# CITY OF MERCER ISLAND

## REVISION/DEFERRED SUBMITTAL FORM

GELOTTE HOMMAS DRIVDAHL  
ARCHITECTURE

Re: Itemized Revisions for Permit 1706-084

L0.2

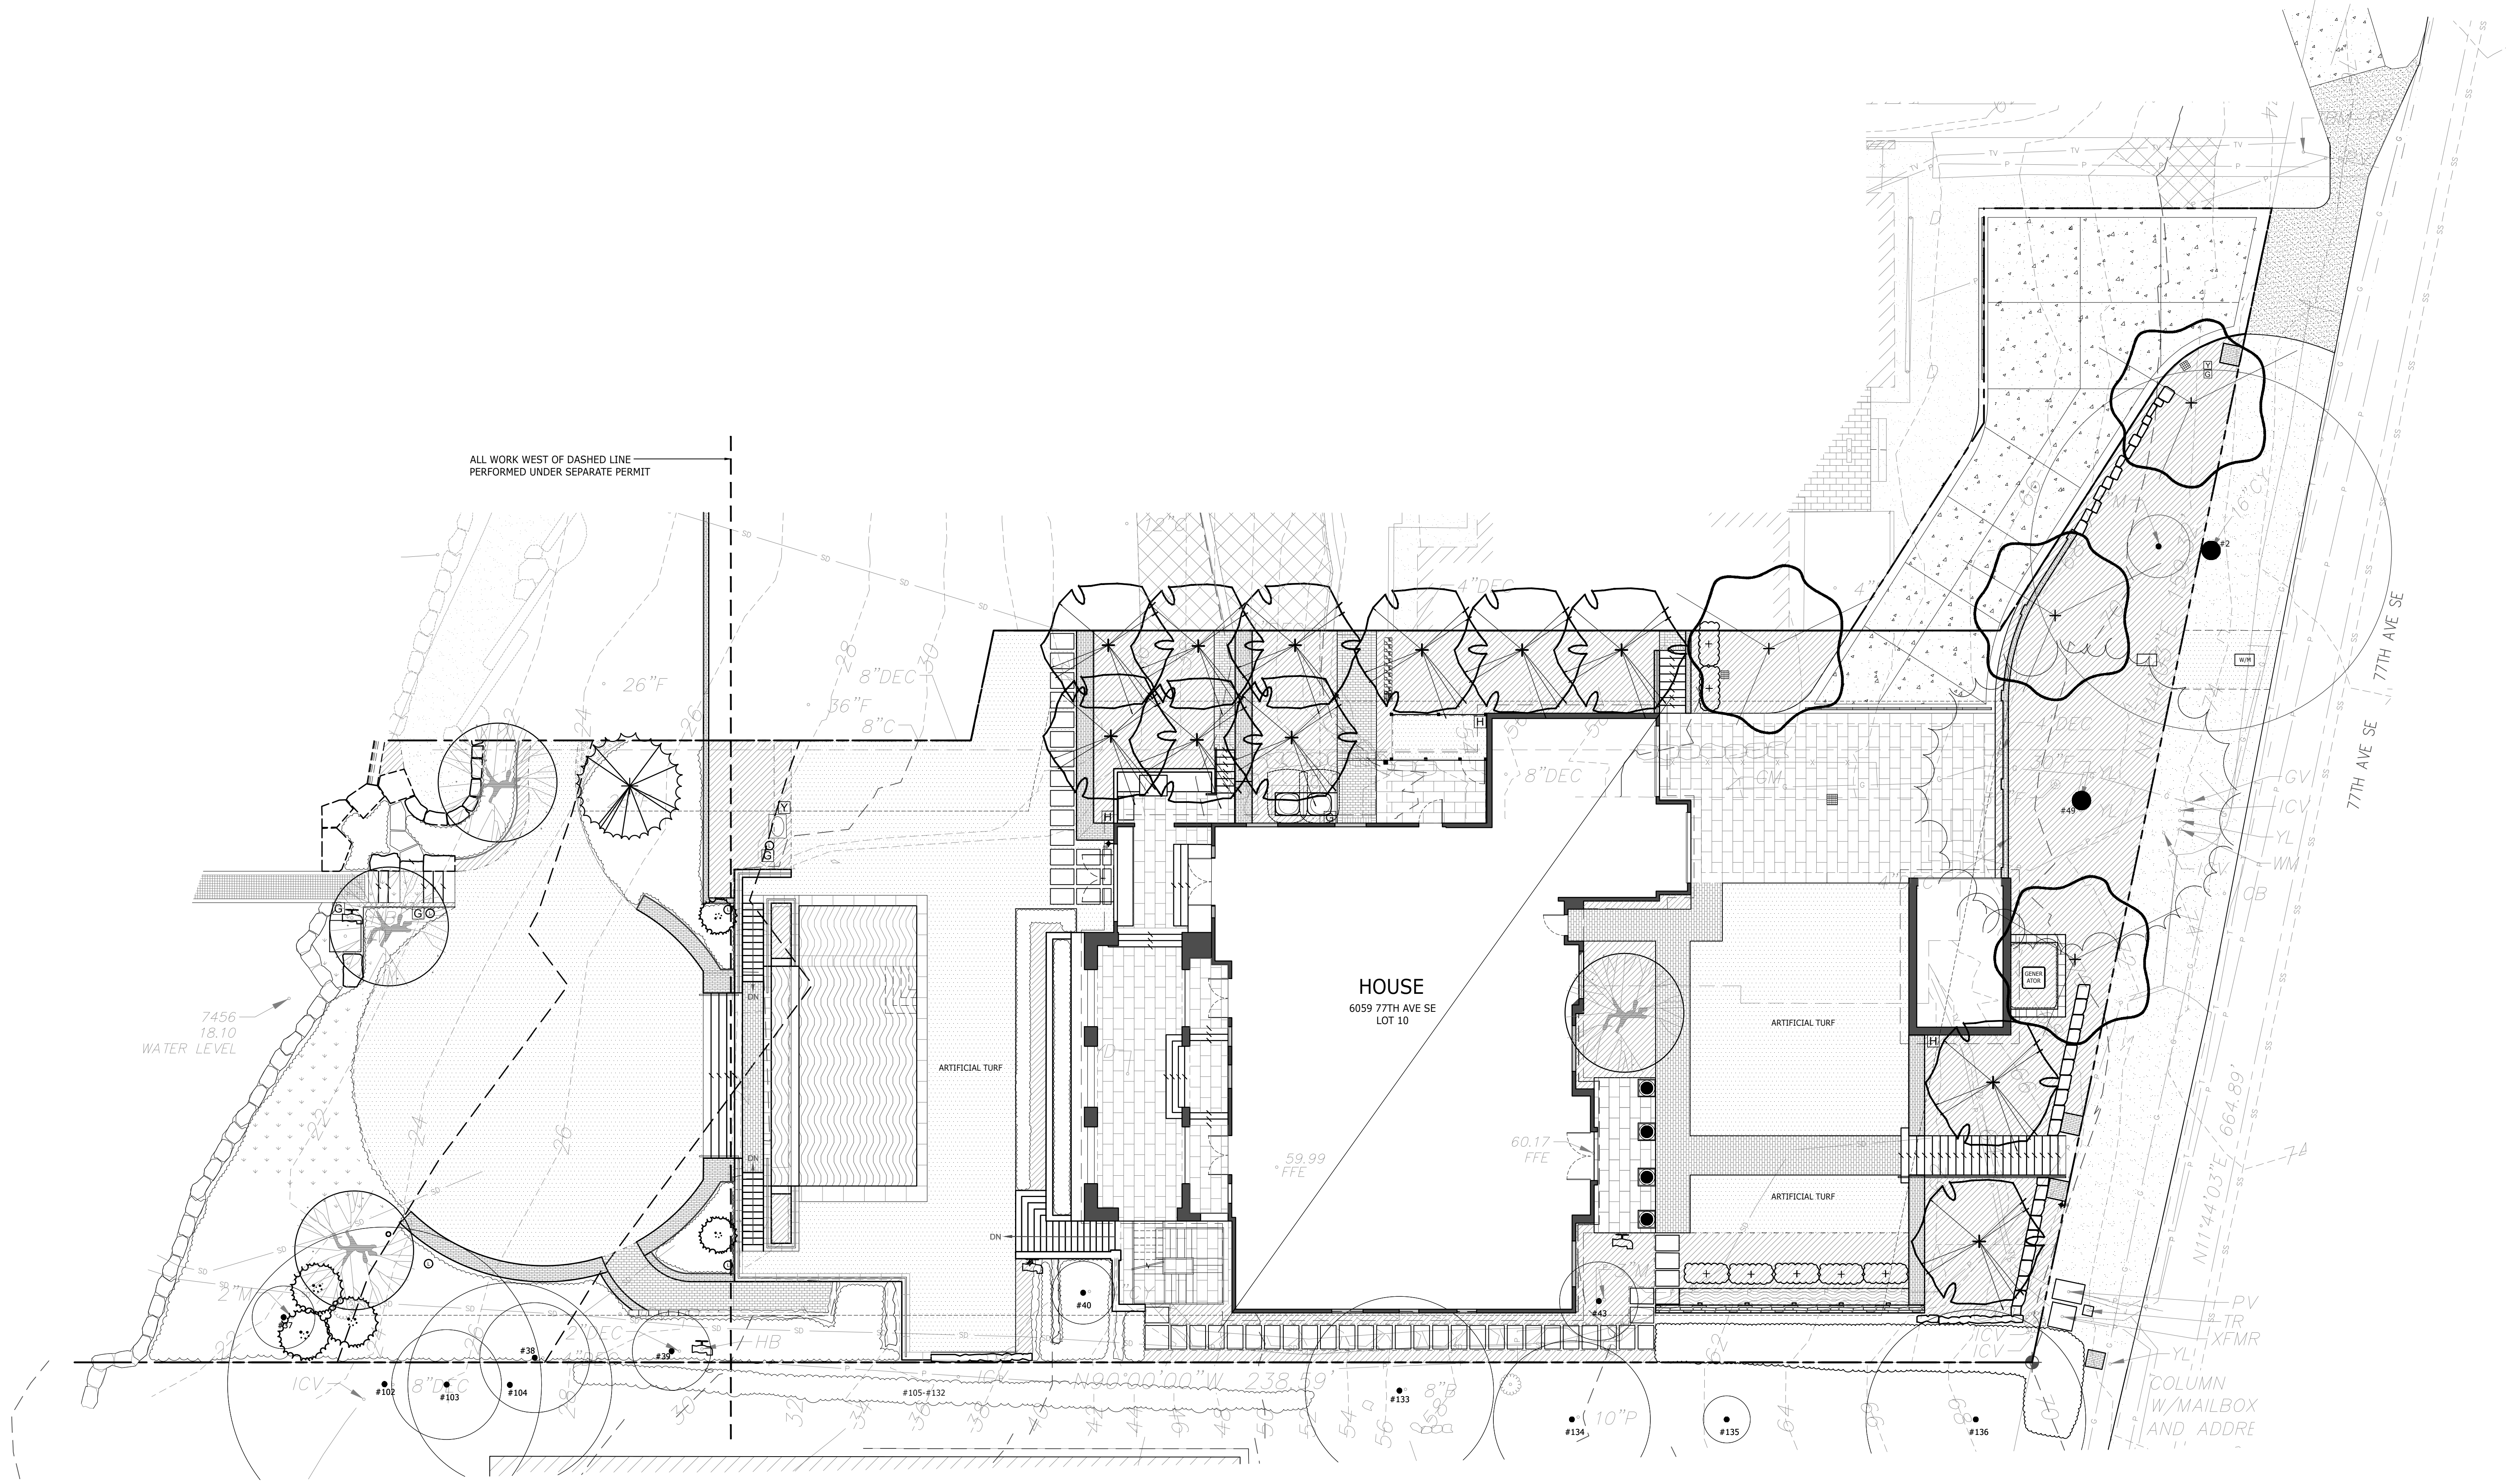
LO.2 Layout Plan: Revised spa, added generator pad, BBQ terrace, etc
